Development Review Board (DRB)
Review Comments
Utility Development Section
Reviewer: Blaine Carter, P.E.
Phone: 505.415.9188

DRB Project No: PR-2021-005927	Date: 09/01/21	Item No: #13		
Zone Atlas Page: F-11	Legal Description: Lot(s) LOT 4, LANDS OF OBLESTER ROMERO			
	Location: 4732 WESTWARD LN between ATRISCO DR and NORTHERN TRAIL			
Request For: PS-2021-00104 – SKETCH PLAT

DRB Project Number: 2021-005927 Hearing Date: 09-01-2021
 Project: Lot 4, Lands of Oblester Romero Agenda Item No: 13

DRB Project Number: 2021-005927
4732 Westward Lane

Plat of
Lots 4-A, 4-B and 4-C
Lands of Oblesster A. Romero
Section 35, Township 11 North, Range 2 East, N.M.P.M.
Albuquerque, Bernalillo County, New Mexico
August 2021

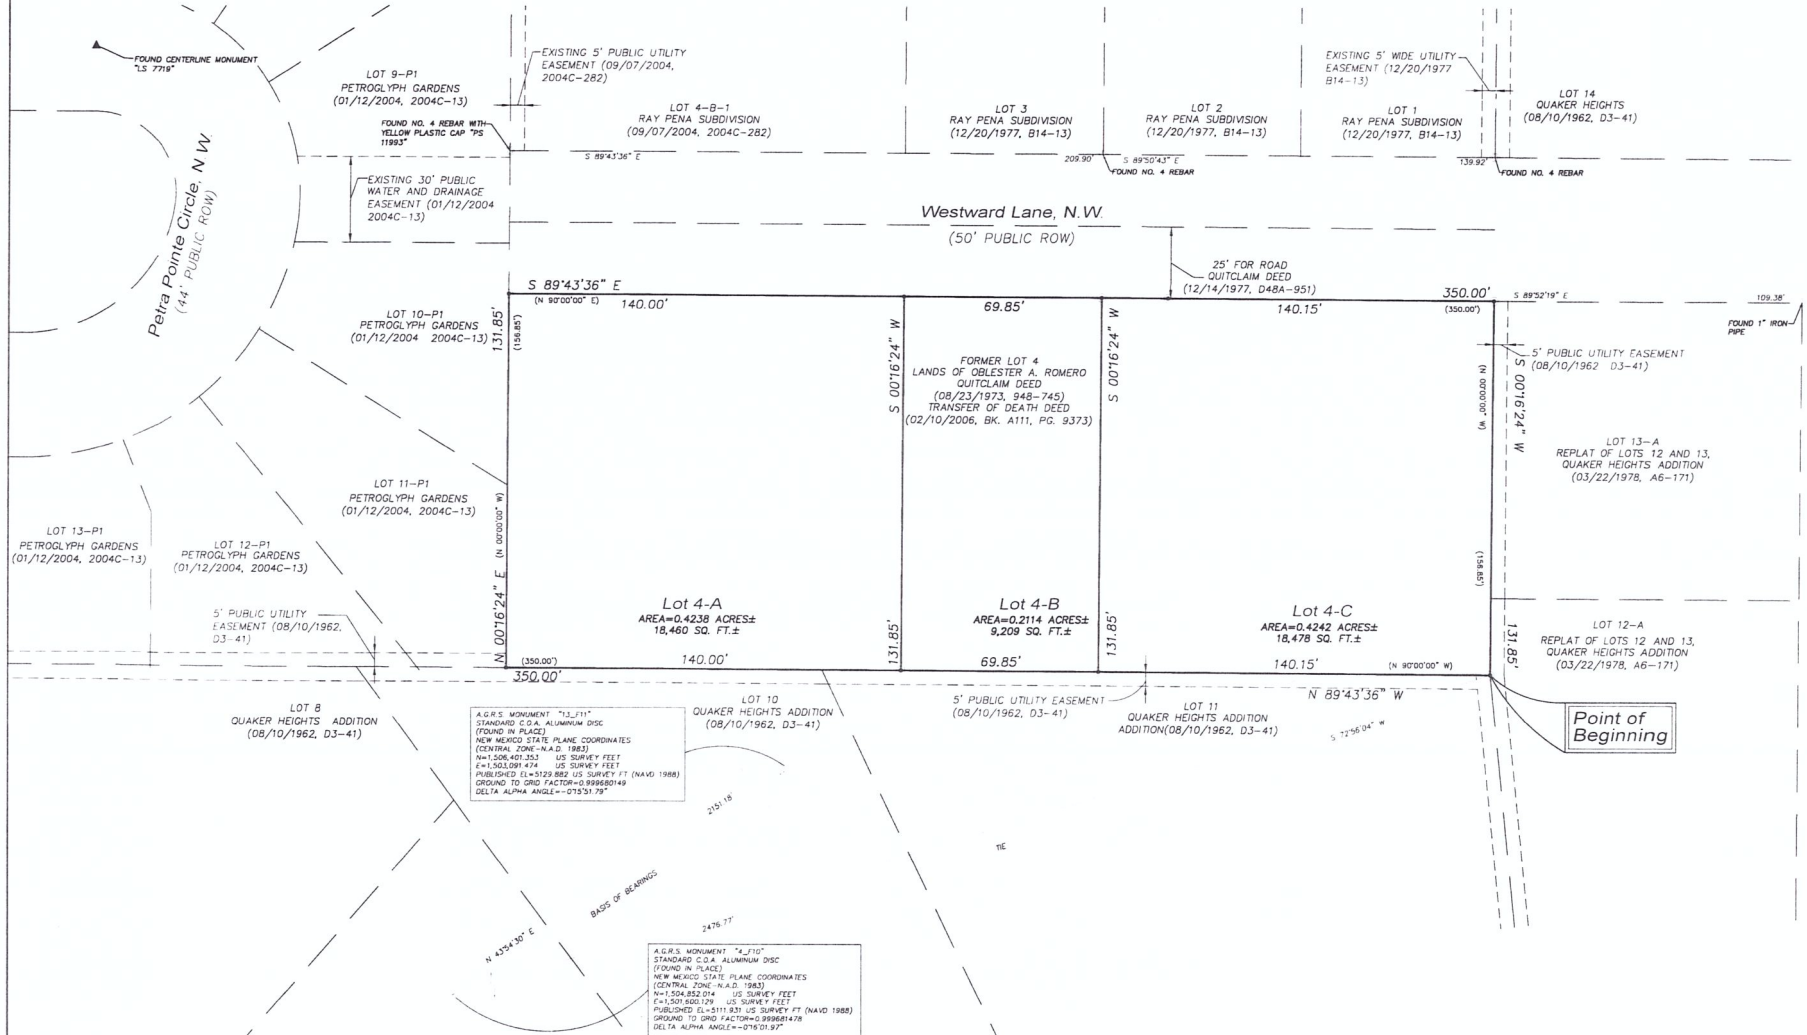
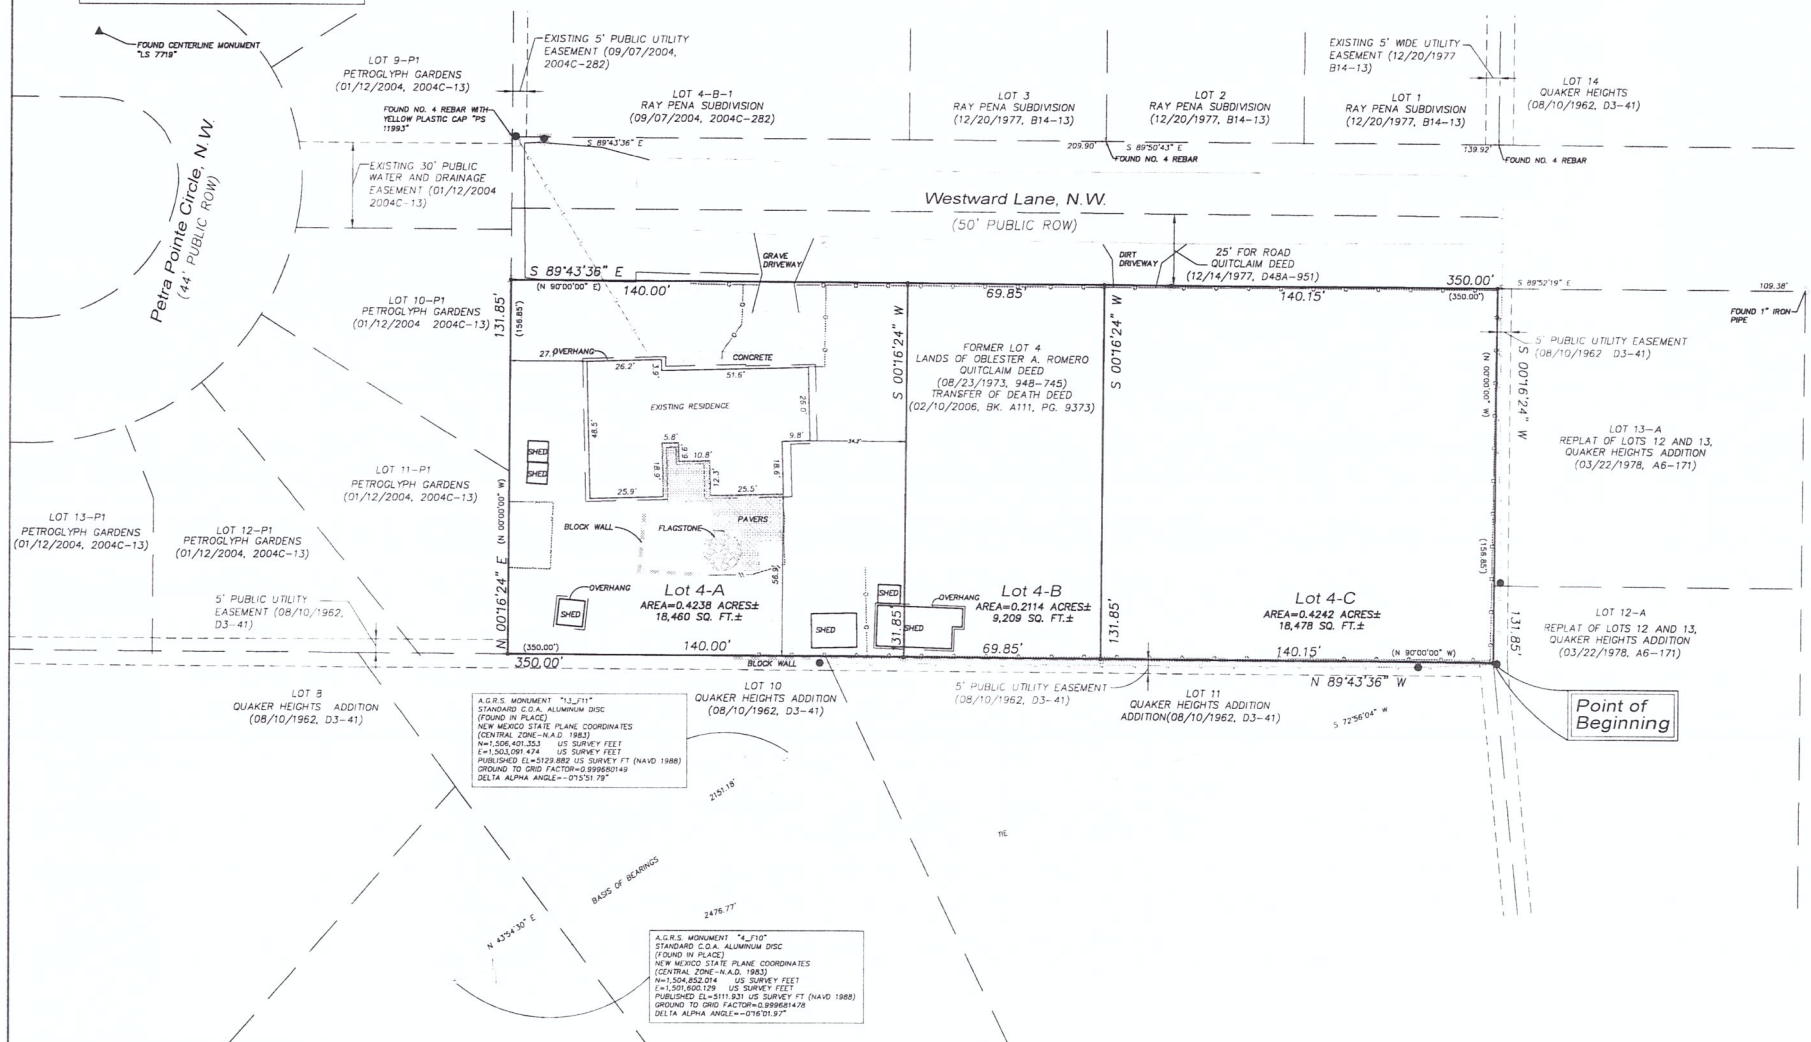
- a. Please indicate the existing service locations if any. As needed, provided private easements such that the existing services can be maintained.
8. Easements:

- The existing shed structure will need to be demolished / removed prior to platting since a proposed lot line is going through the structure.

Confirm that the existing building will meet setback requirements with the proposed lot lines
